# CITY OF ALBUQUERQUE

June 20, 2023

**Re: Copper Terrace Building A**  
**12801 Copper Ave. NE**  
**30-Day Temporary Certificate of Occupancy**  
**Transportation Development Final Inspection**  
Architect's Stamp dated 11-16-21 (K22-D062)  
Certification dated 06-13-23

COPPER TERRACE APARTMENTS
RECONSTRUCTED BUILDING A12801 COPPER AVE NE
ALBUQUERQUE, NM 87123

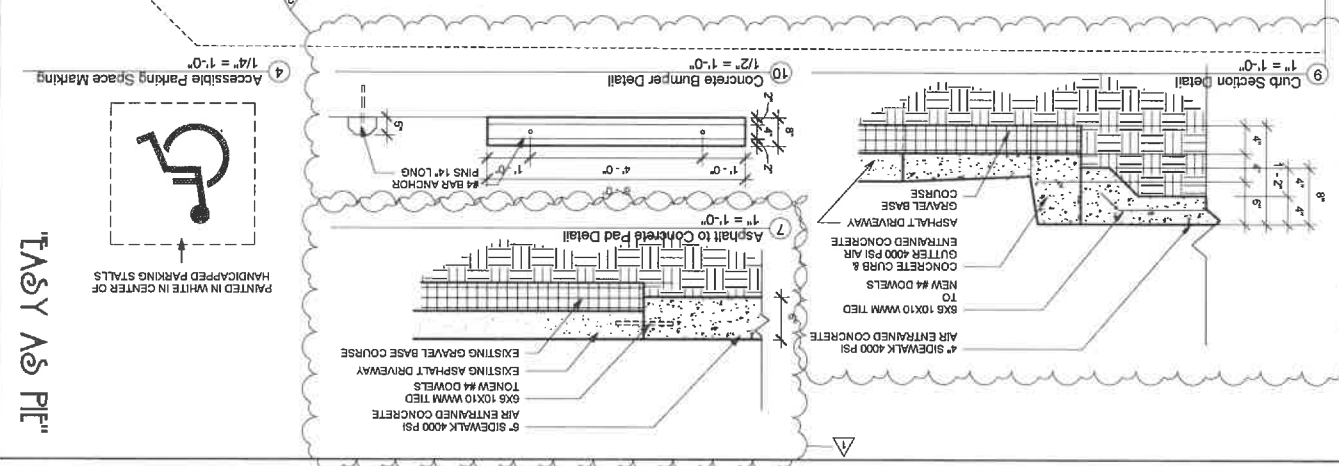
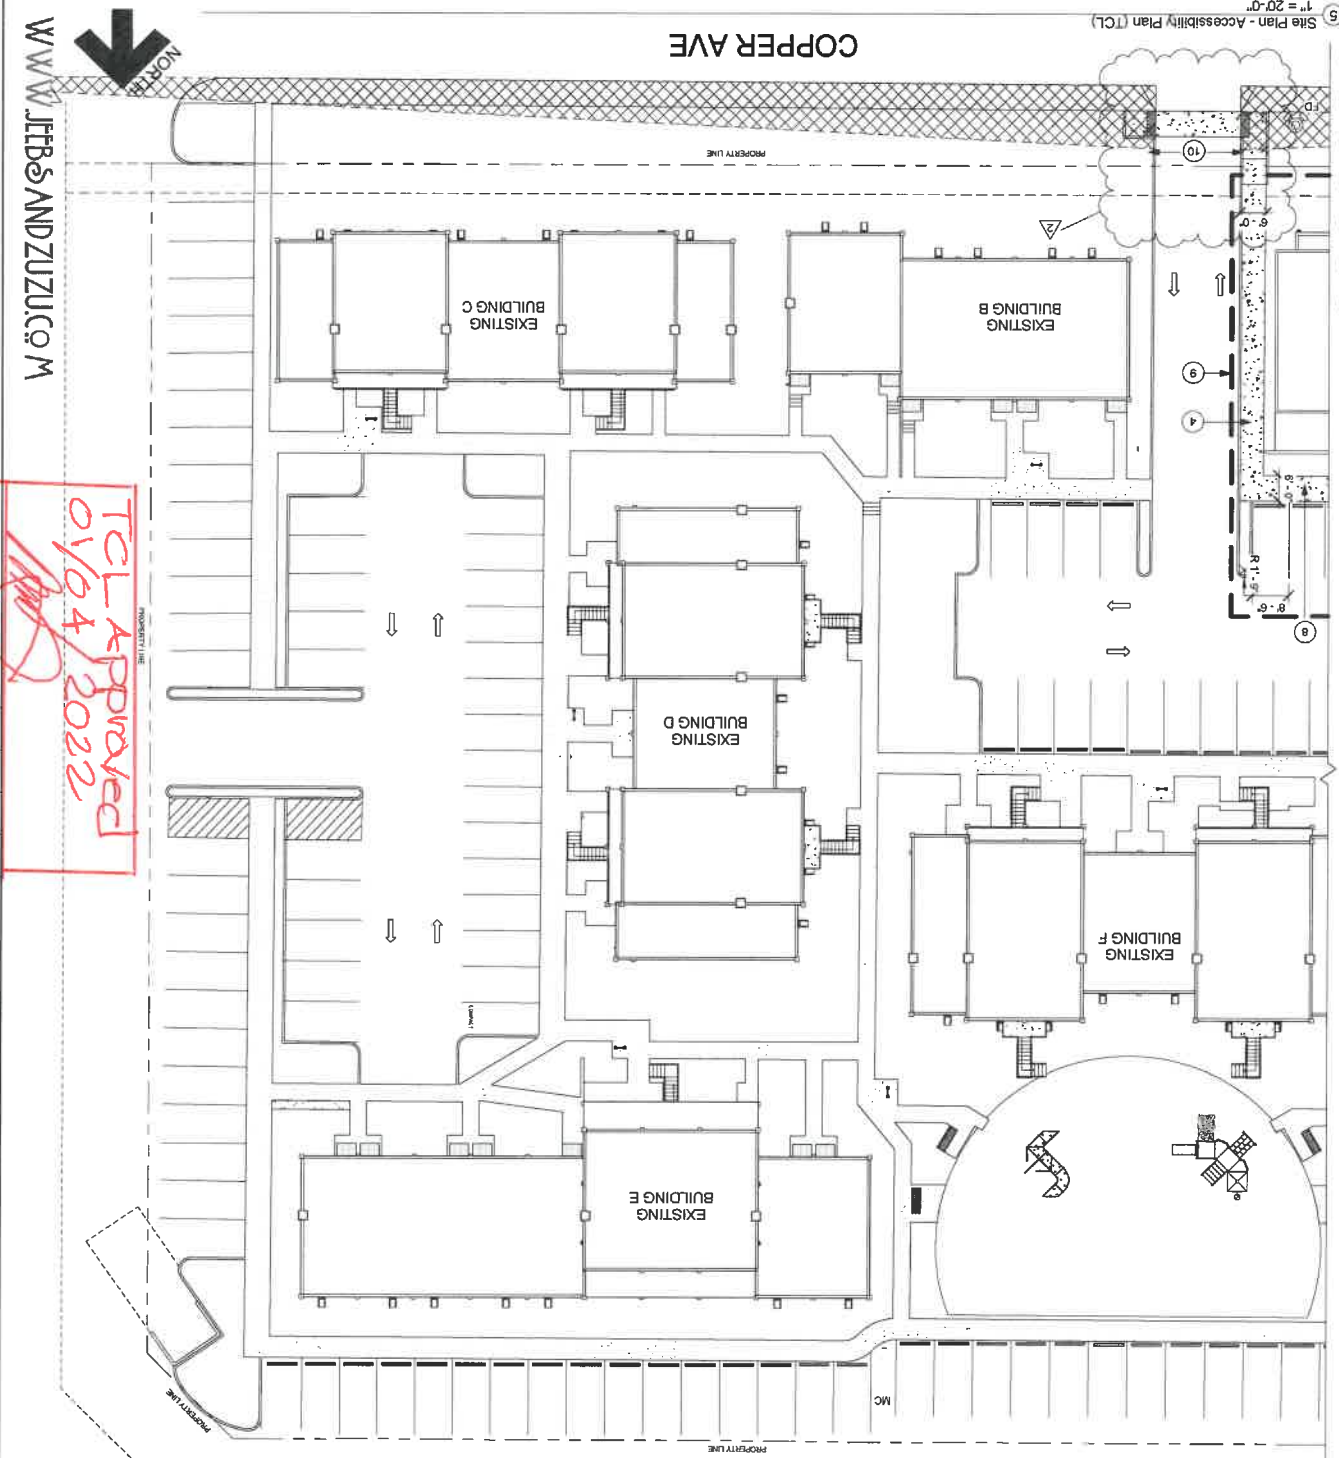
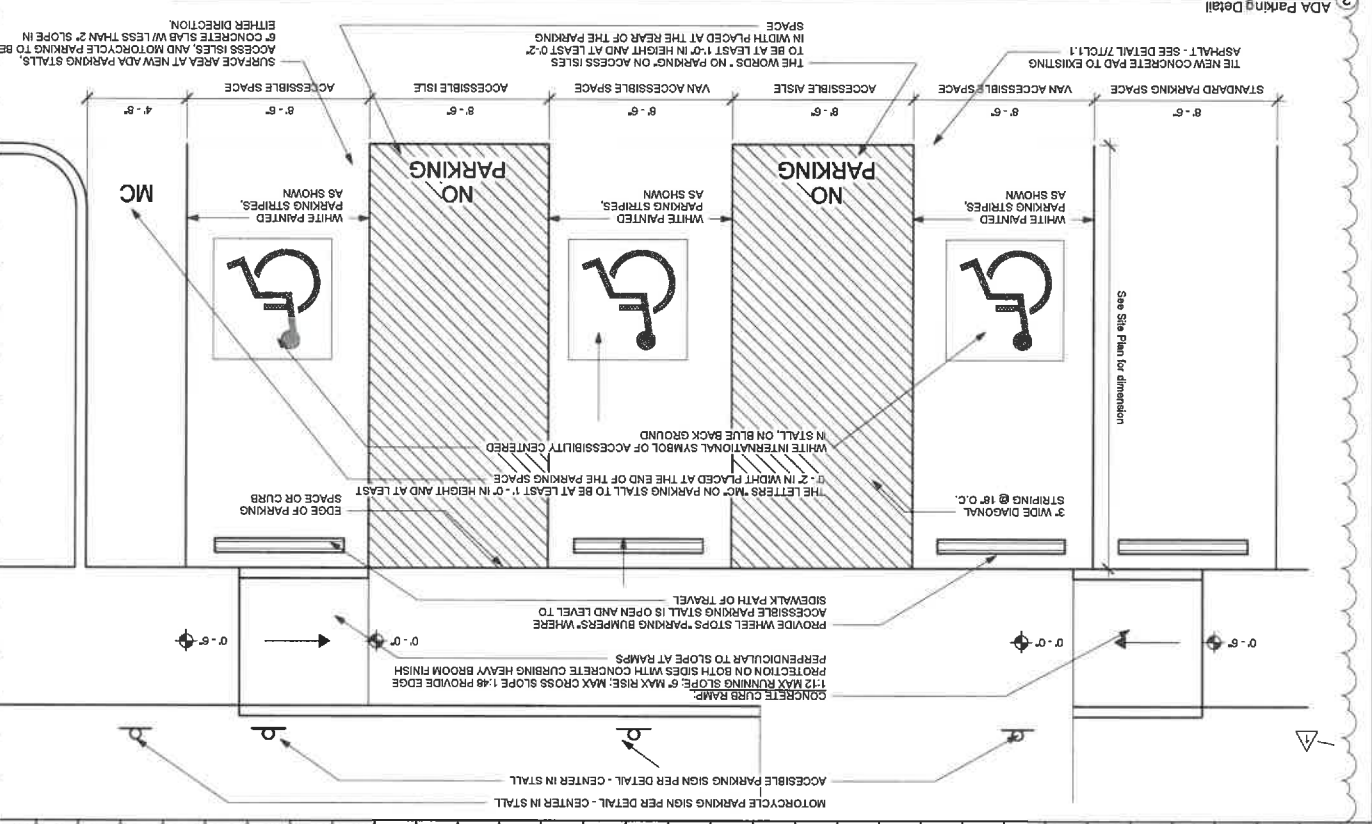
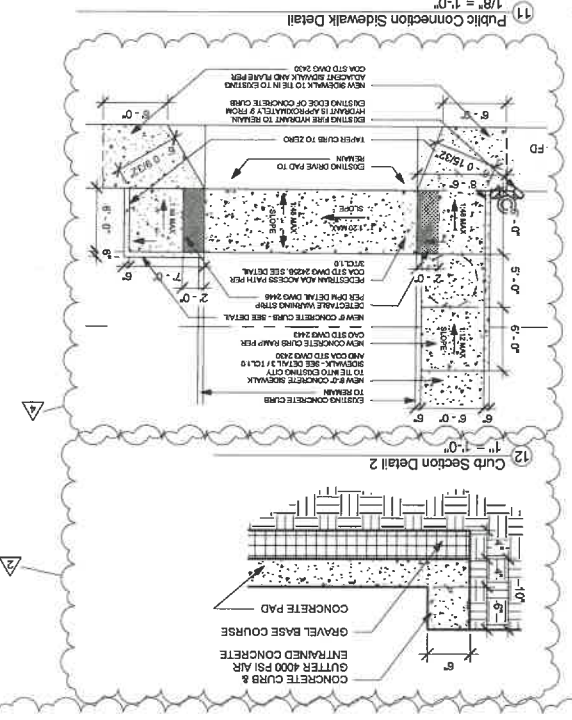
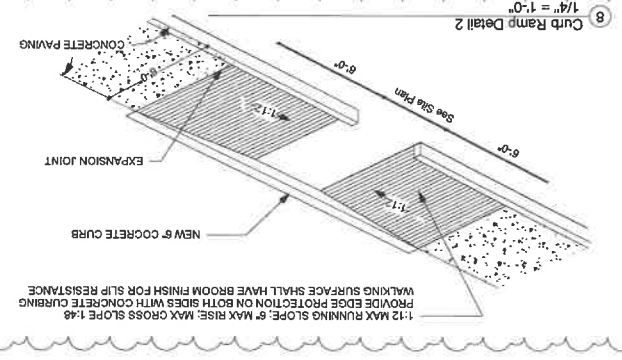
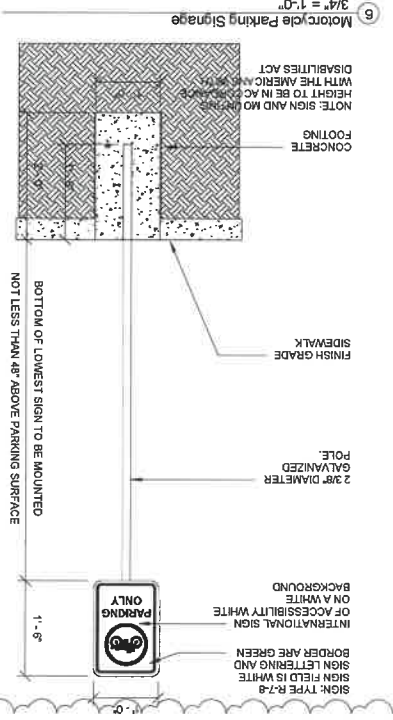
- Site access off Copper Ave. must be built per approved plan.
- The pavement marking "MC" should be shown in the opposite direction for motorcycles entering the parking space.
